From: Contact Centre (CRM) <contact@ribblevalley.gov.uk>
Sent: 06 June 2023 21:24
To: Planning
Subject: Planning Application Comments - 3/2023/0352 FS-Case-521976041

Planning Application Reference No.: 3/2023/0352

Address of Development: 10 Manor Road, Whalley BB7 9TE

3 PROPOSED SOUTH  
1 : 50

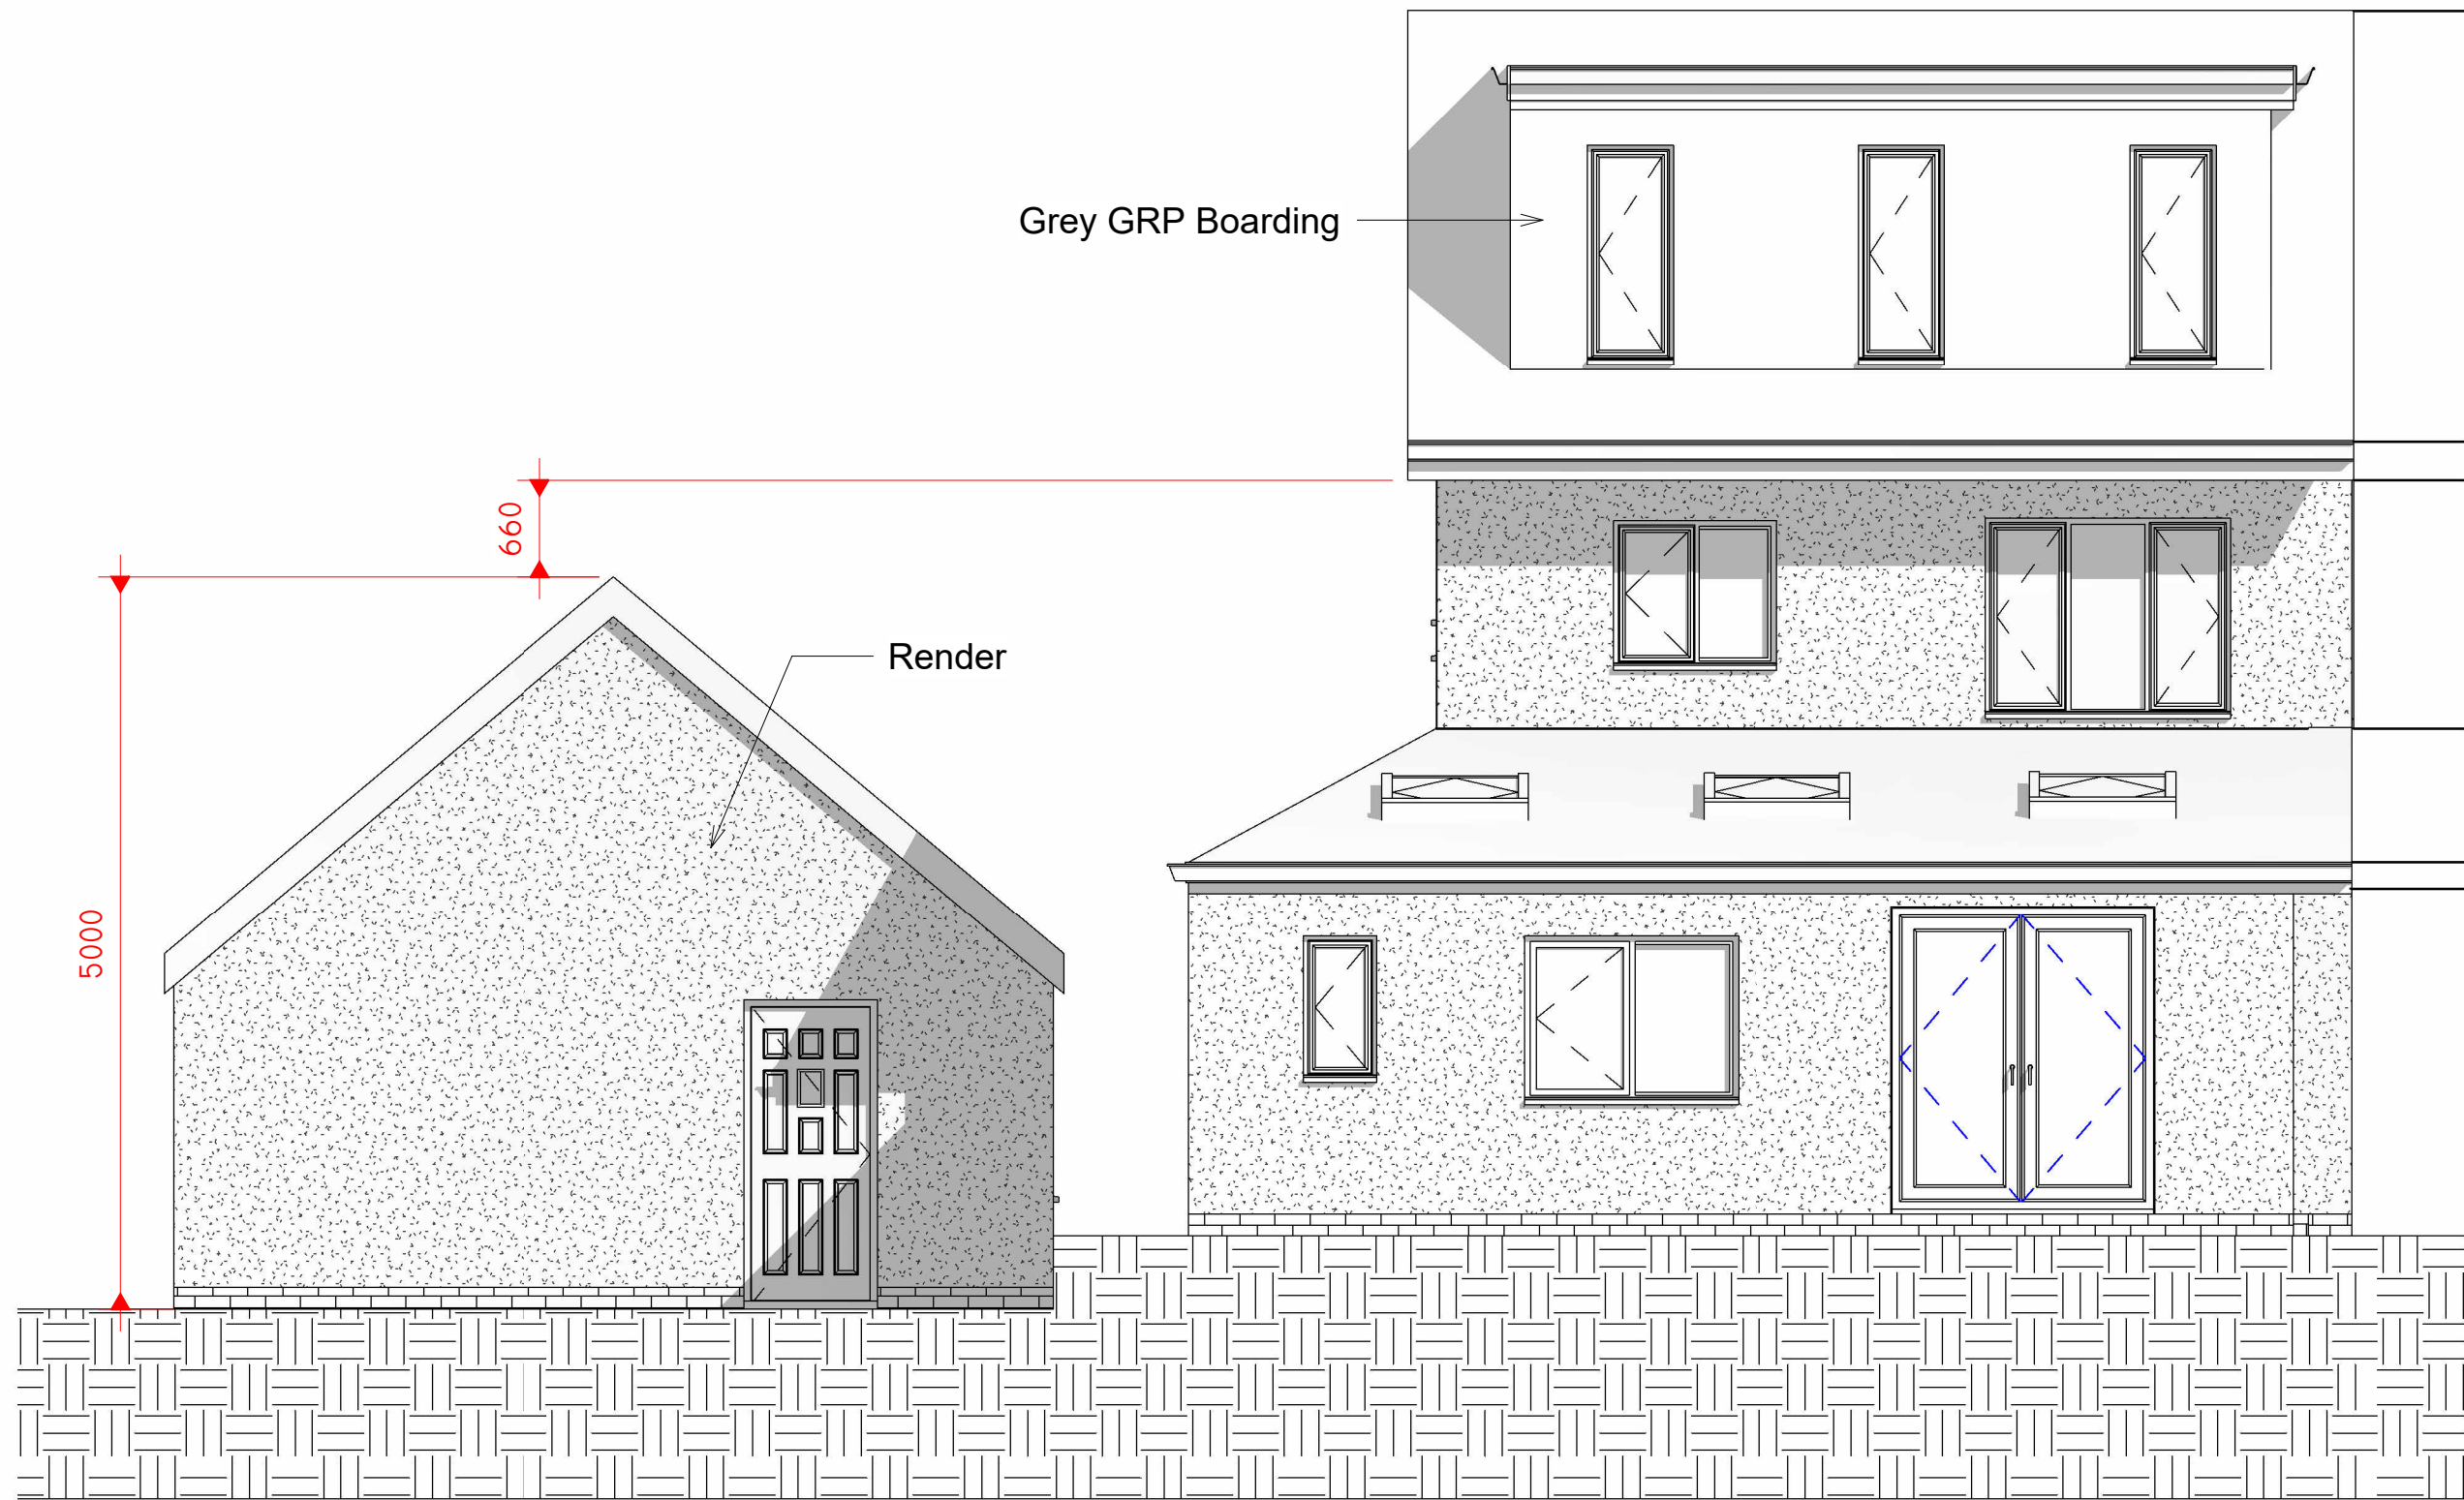
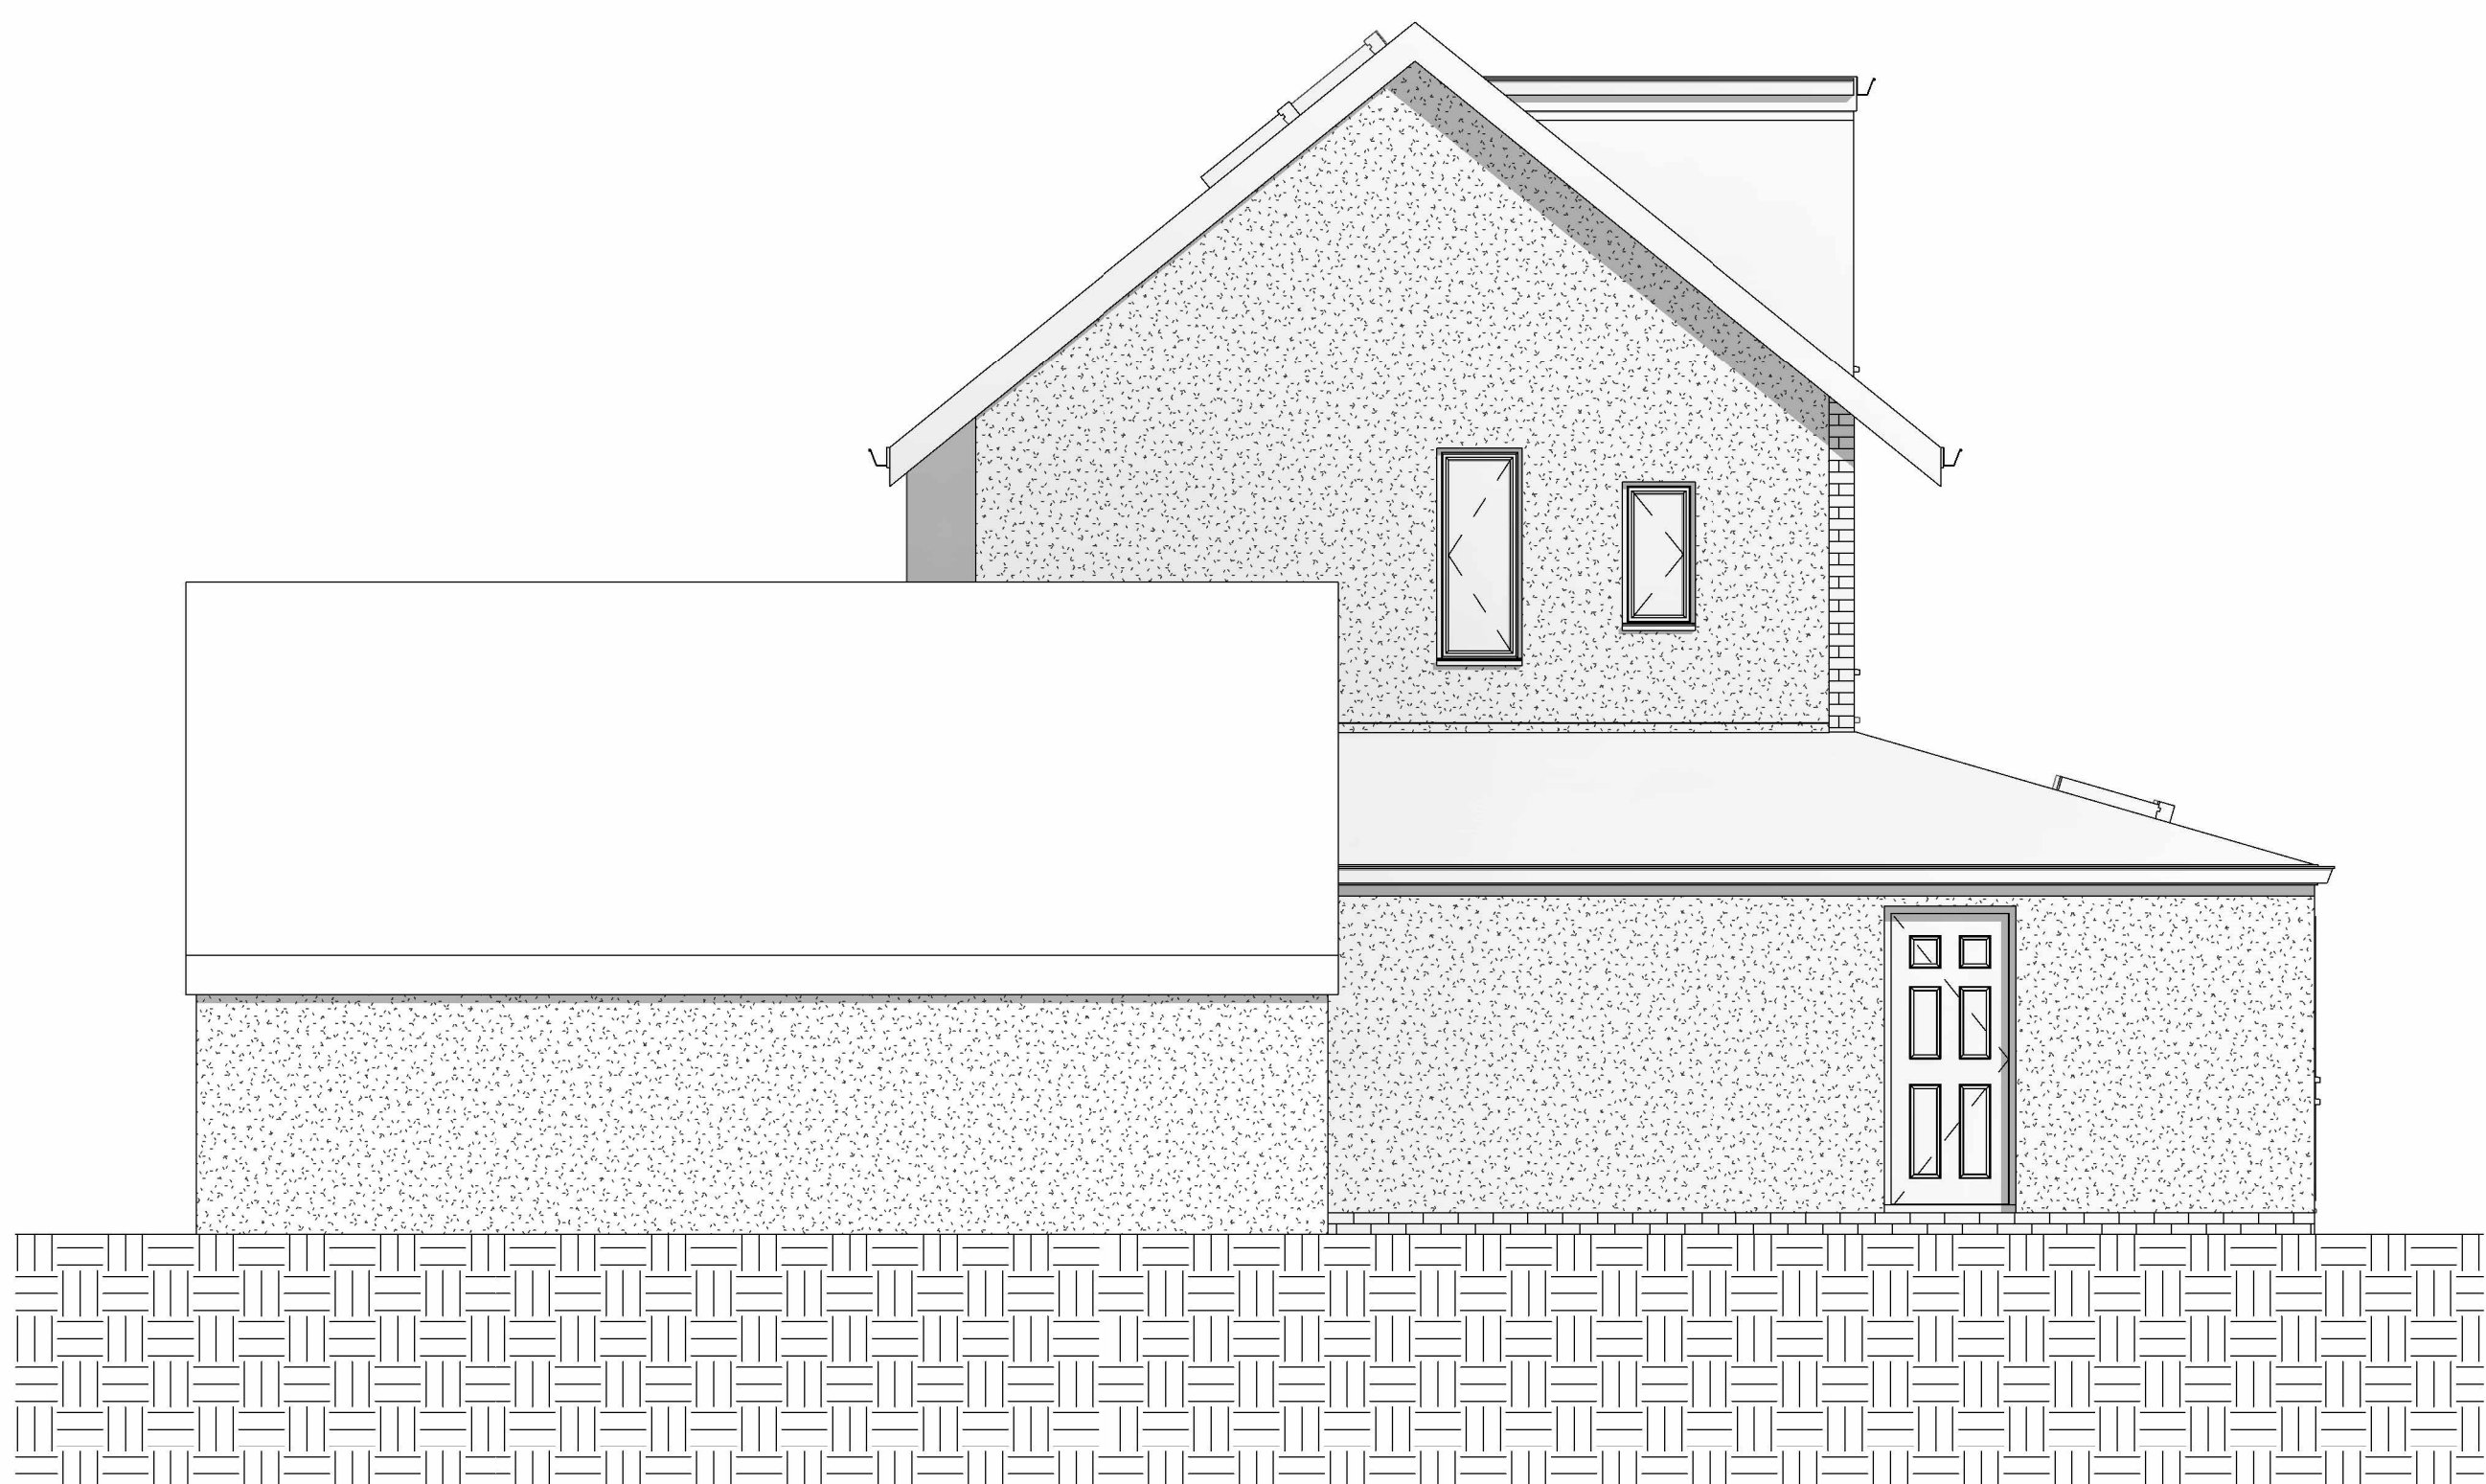
- 1) Confirm the rear extension (that is [REDACTED] will be constructed wholly on the land of no 10 Manor Road - [REDACTED] Out of interest not received any correspondence in relation to the [REDACTED]...which I'd have thought would be necessary ?Would also be interested to know if the owner/contractor believes they'll be accessing [REDACTED] actually construct this rear extension ?
- 2) Because the proposed rear extension is to extend 1m beyond its correct line/footprint, which means the existing lean-to roof will be at a different angle, what is the intended arrangement/detail between the new lean-to roof and next door (where the steeper pitch remains the same);
- 3) Not sure if square bay windows are to be constructed or angled bays - as the proposed plans show square and the elevations show angled (while not particularly bothered either way - would be good to know).
